**Re: Bedrock at The Trails Units 2 and 3 at 9300 Woodmont Ave. NW
Erosion and Sediment Control Plan
CPESC Stamp Date 11/21/24 & PE Stamp Dates 7/18/24 & 7/31/24 (C09E011B)**

Based on the information in your submittal received on 11/26/24 consisting of Sheets ESC 1-3, the DMP, and 39R and 40R of the Phase 1 work Order Plans, the following comments must be addressed before approval.

# STORM DRAIN POND A6-2 TO POND D1

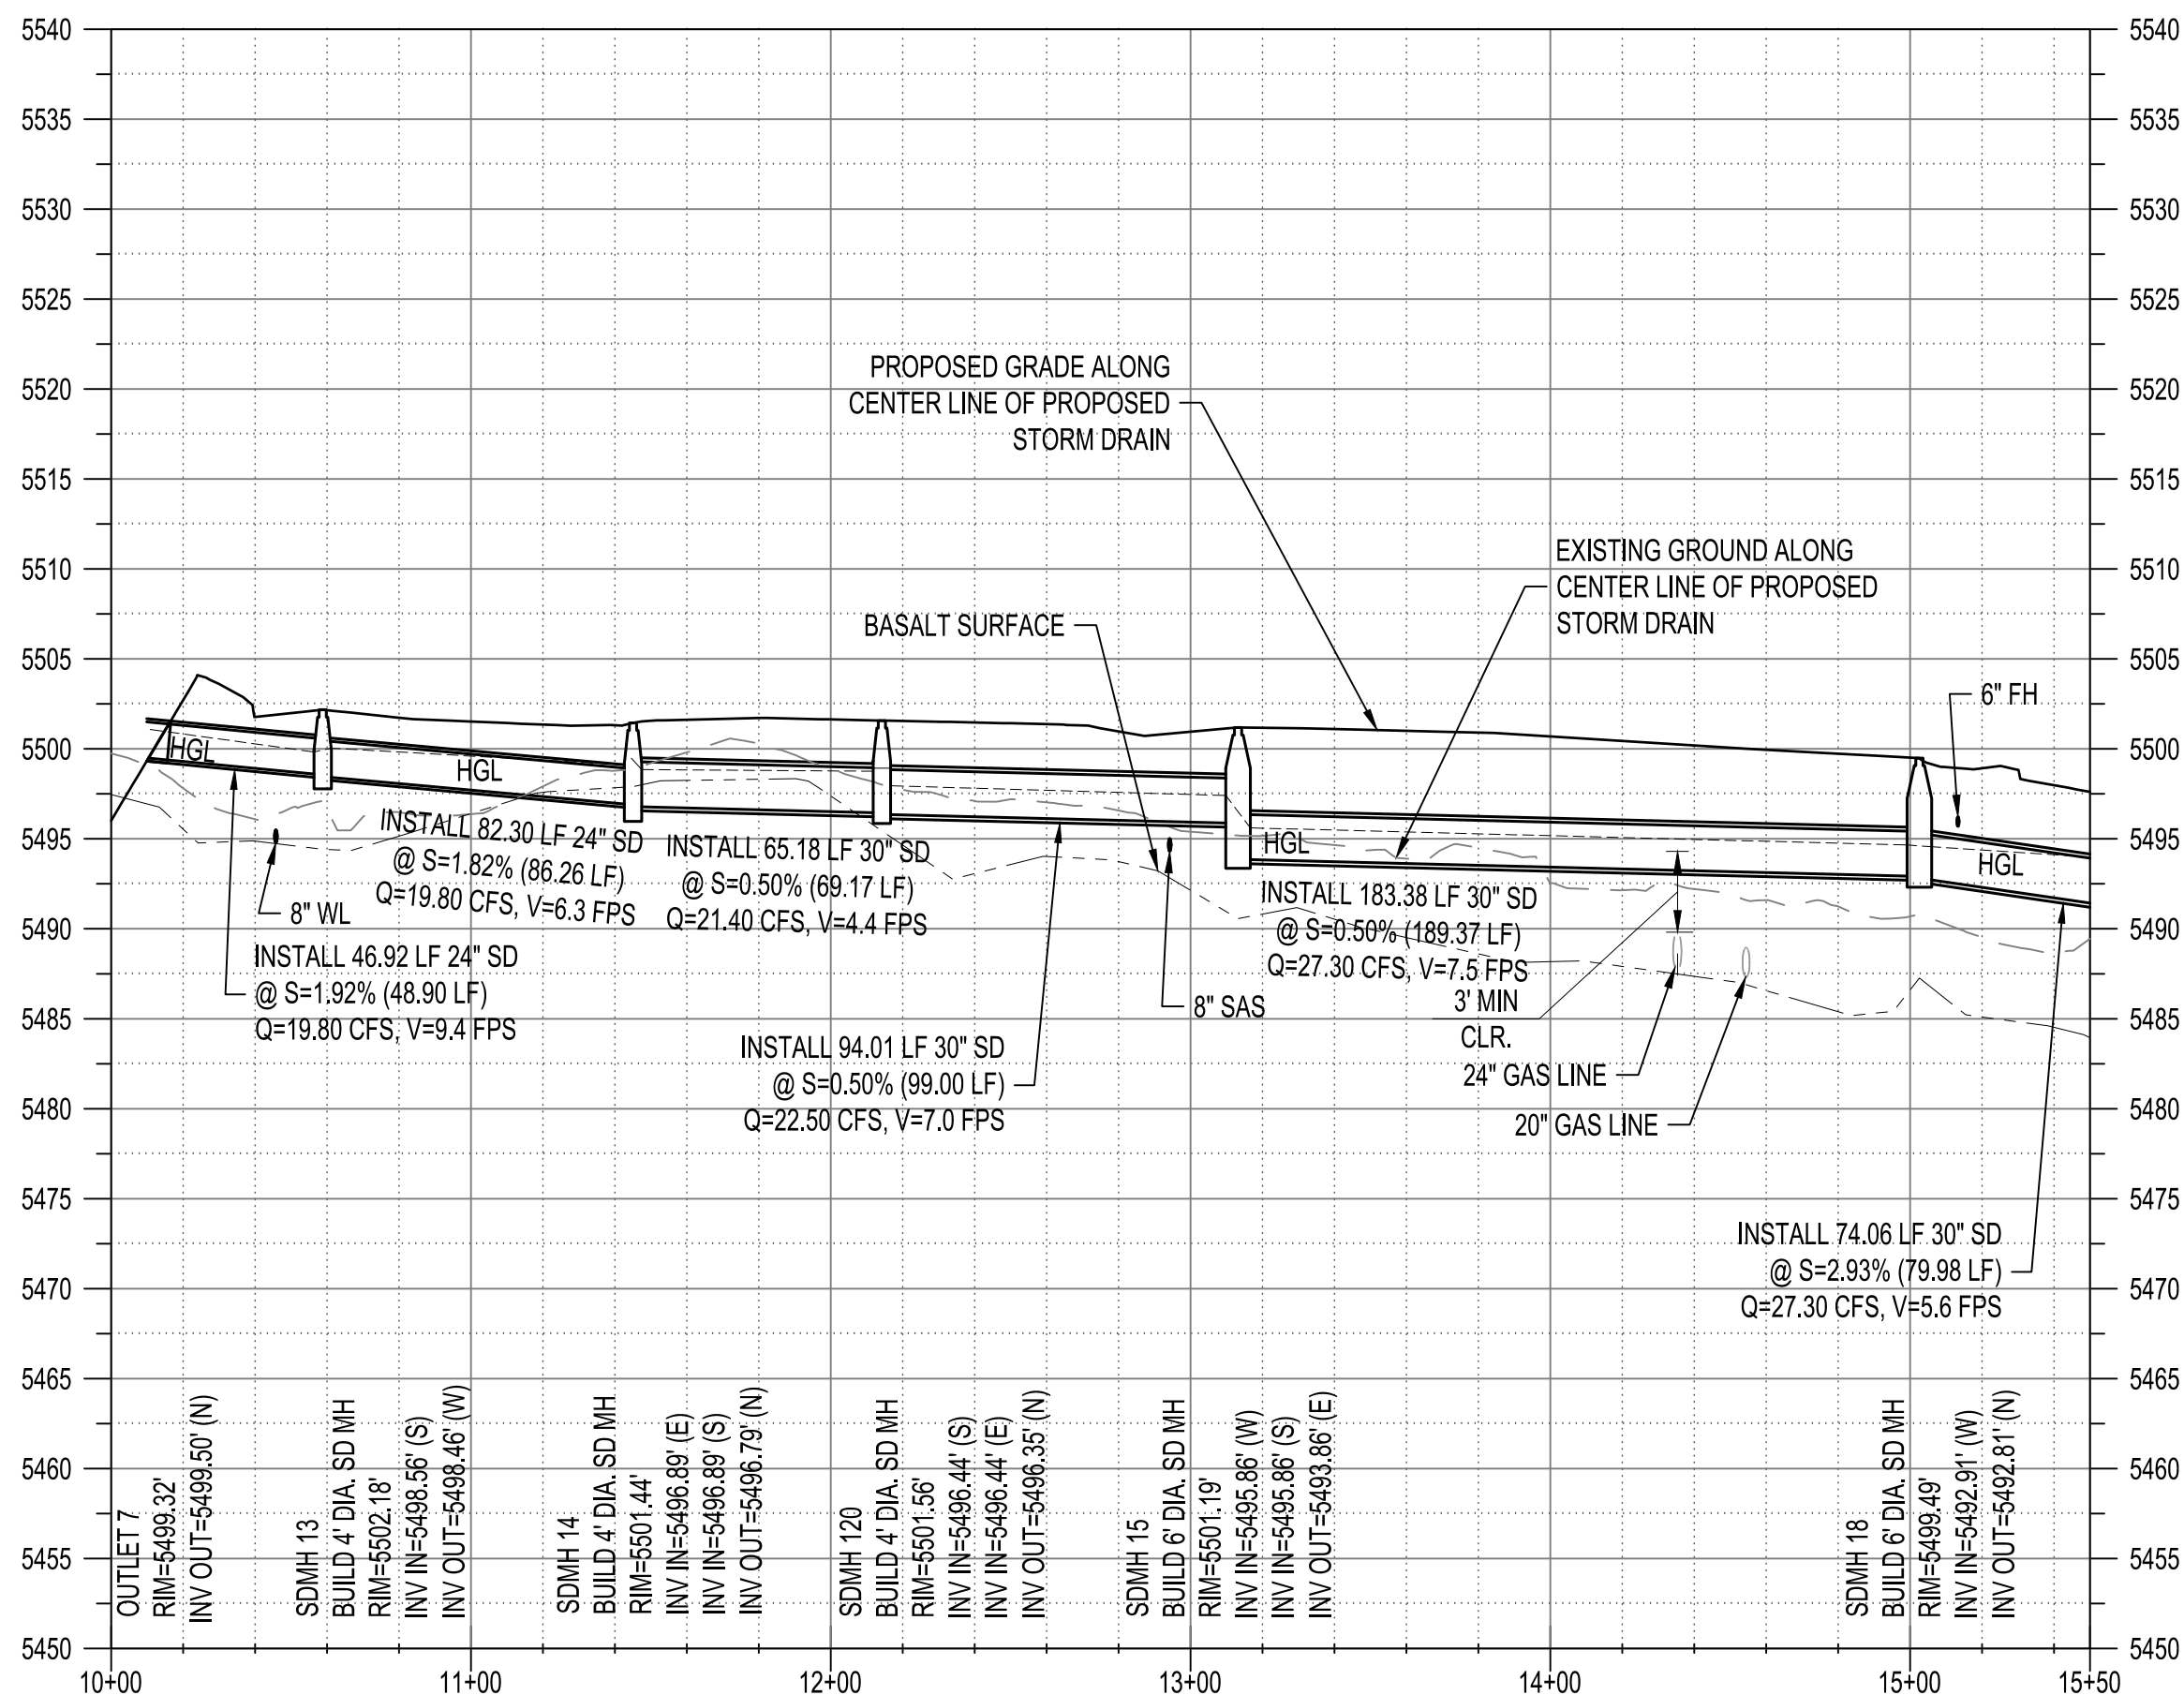
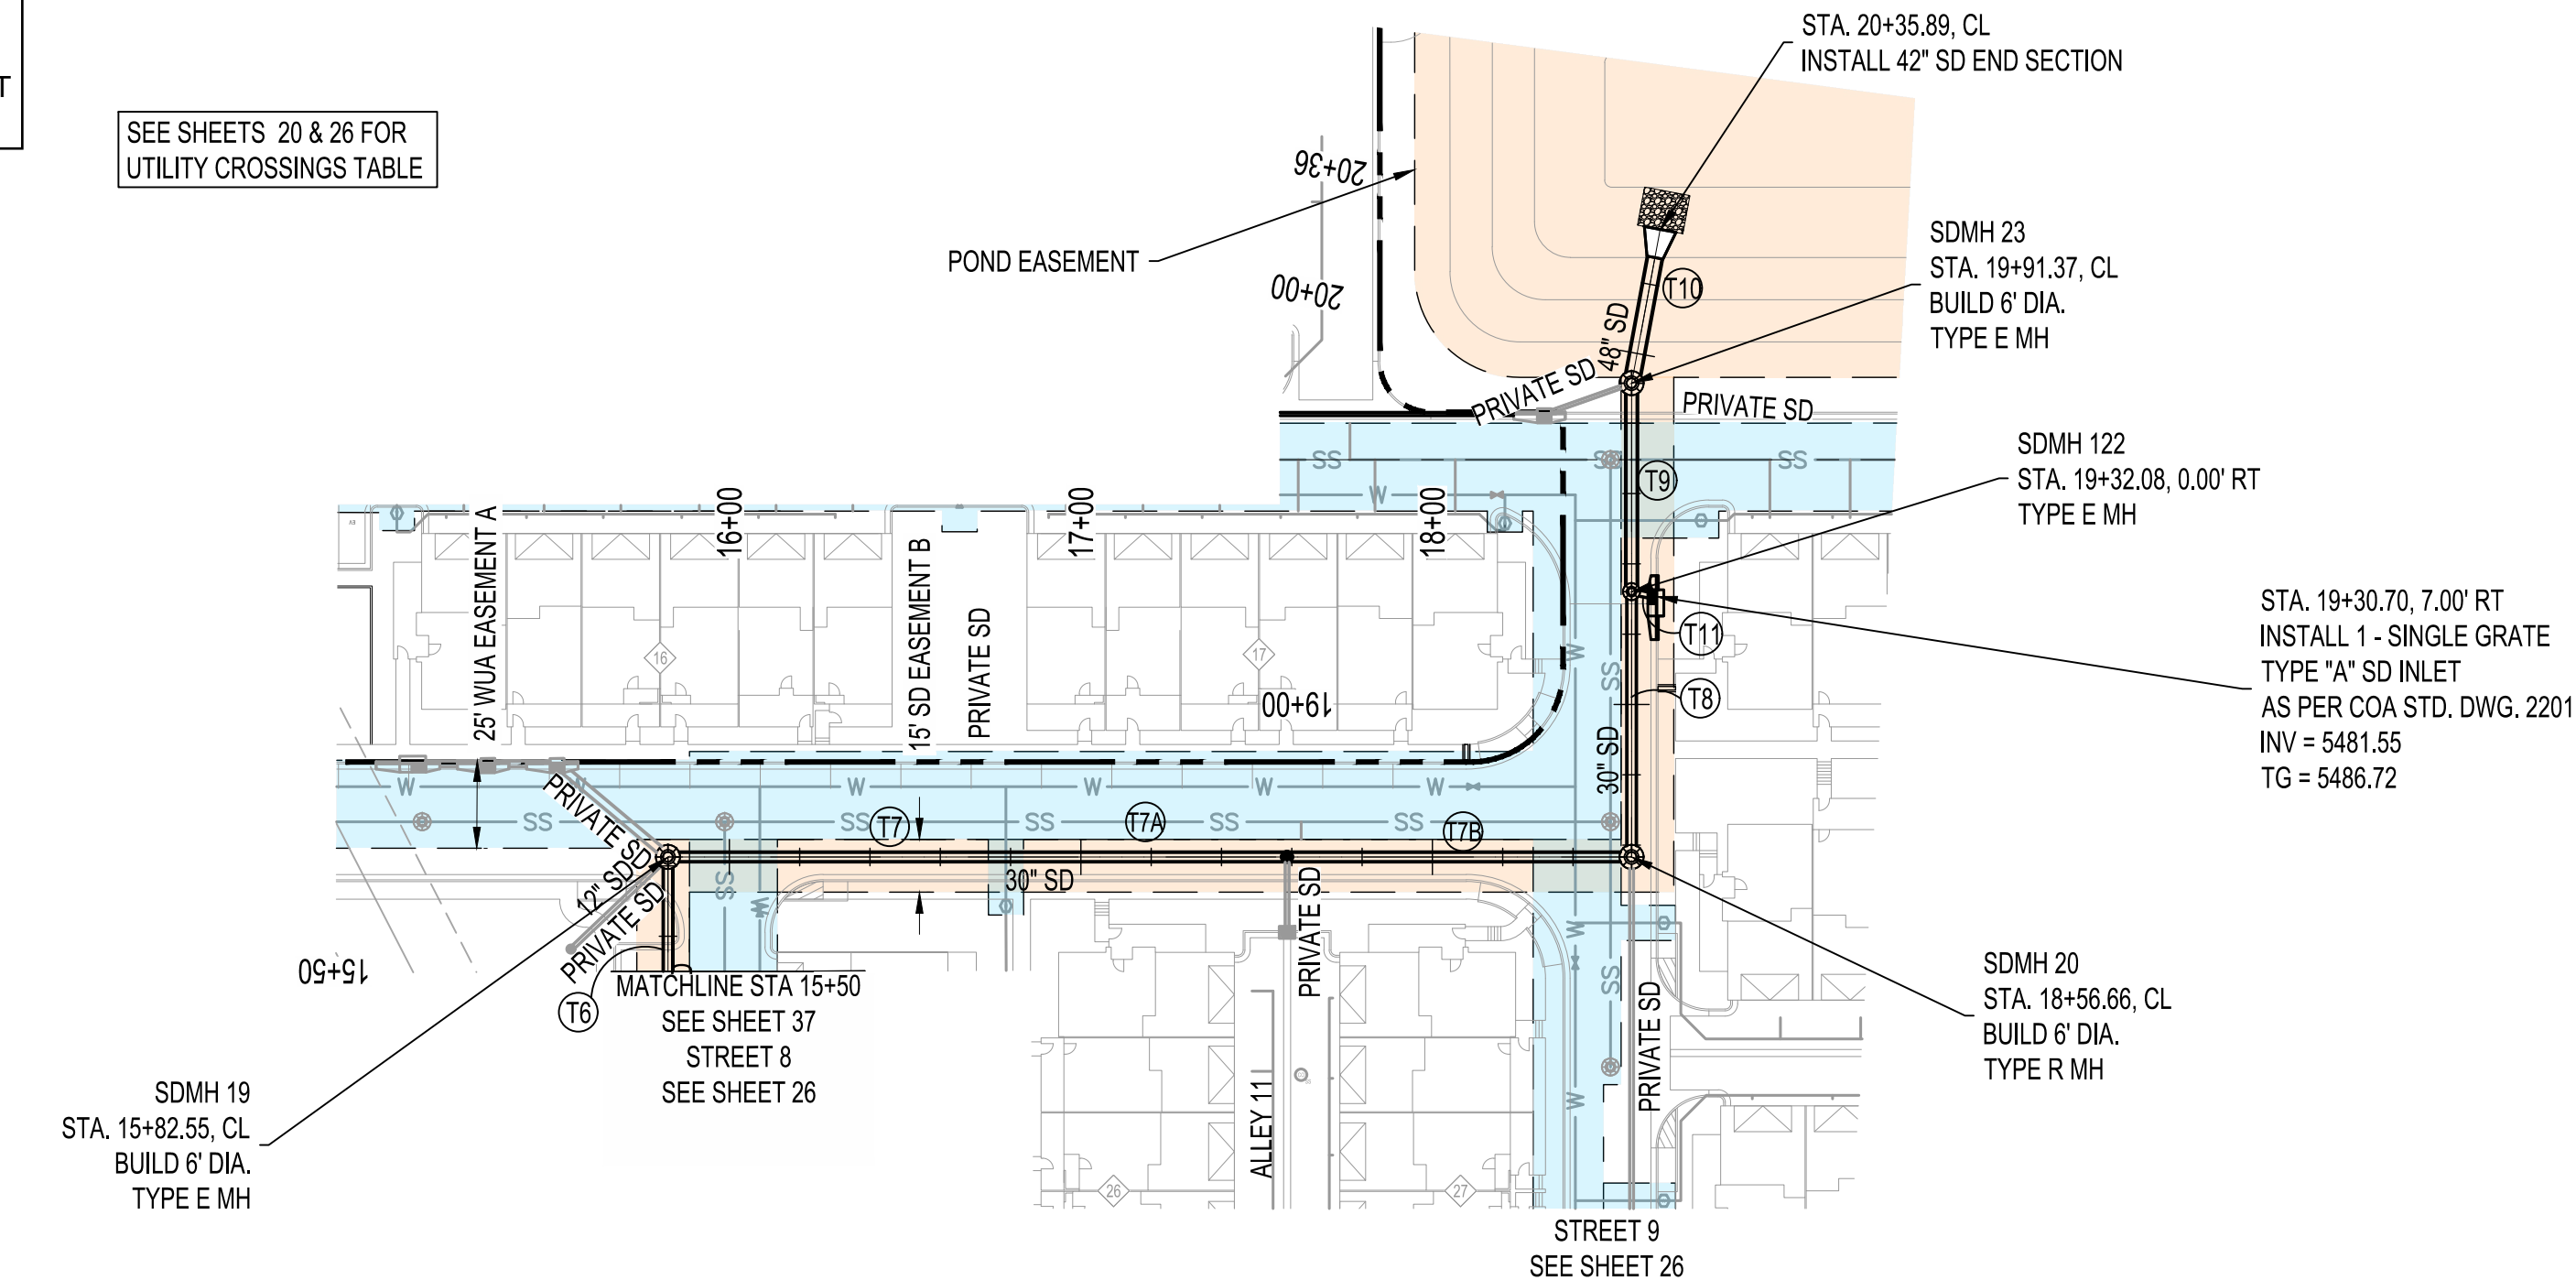
1. The construction sequencing on sheet ESC-2 says, in essence, that the outfall pipes from ponds D1 and A6-2 will be plugged until all of the buildings and infrastructure construction and stabilization are complete. However, the engineering sheets don't indicate that that condition is safe, nor is there any indication that the condition has even been considered by the professional engineer (PE). So, provide a hydrologic summary of how those two ponds will function with plugged outlet pipes at full buildout. The summary should be stamped by a PE and included in the Work Order and ESC Plans. The summary should include a description of the conditions, the 2-yr and 100-yr 24-hour volumes, peak flow rates, and peak stages in all ponds.
